Our Ref: EP/55/11/

14th June 2011

Loft conversion and small extension to rear
21 Normandy Lane East Preston

DRAWING	SCALE
EXISTING ELEVATIONS	1:100 @ A1
PROPOSED ELEVATIONS	1:100 @ A1
SITE PLAN	1:500 @ A1
LOCATION PLAN	1:1250 @ A1

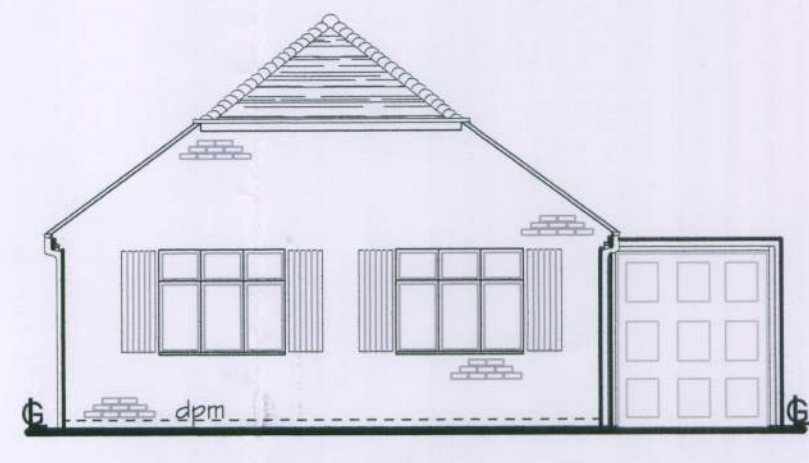
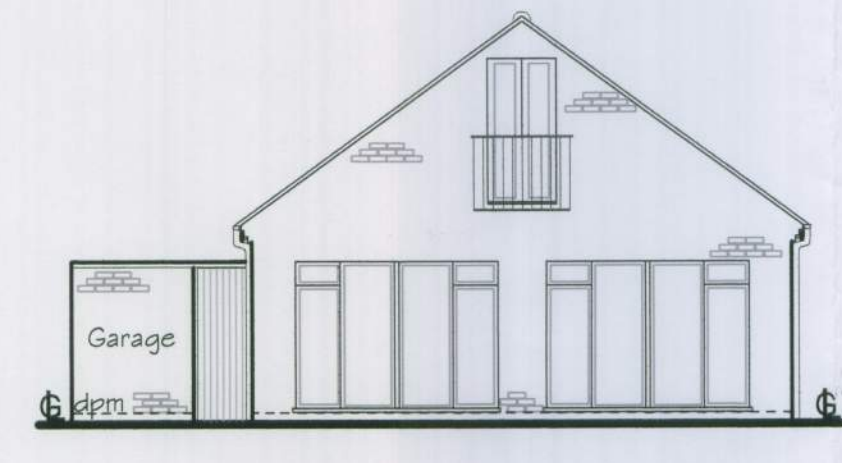
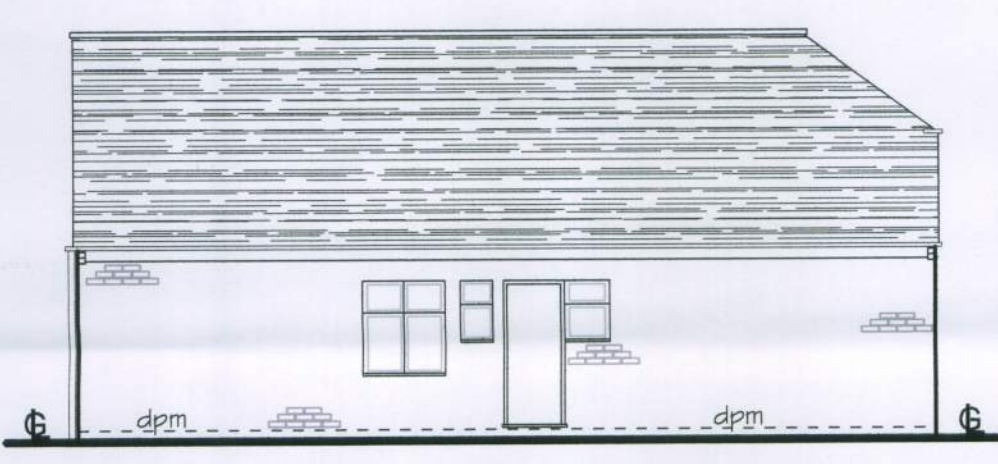
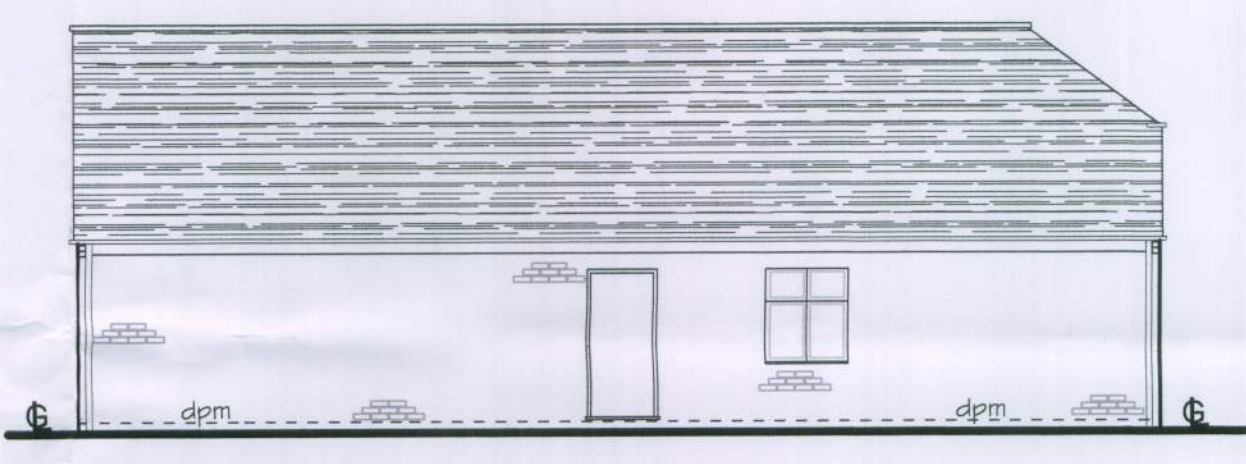
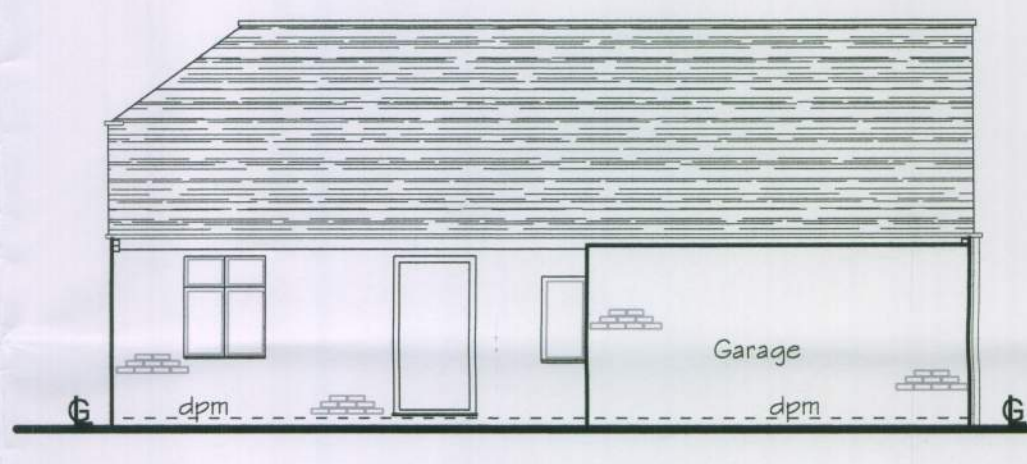
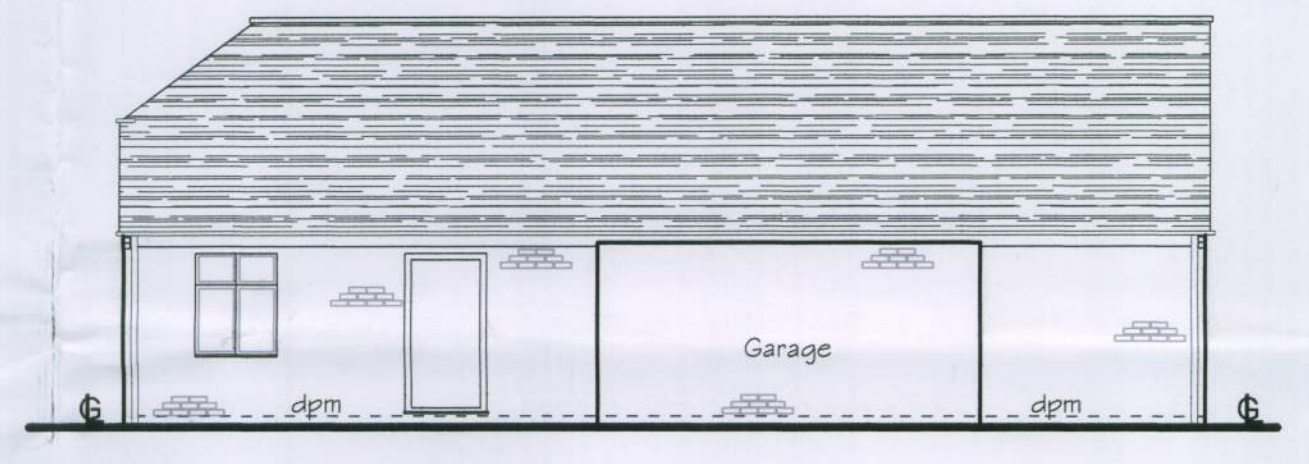
However, it was disappointed that the proposed elevations did not show the velux windows.
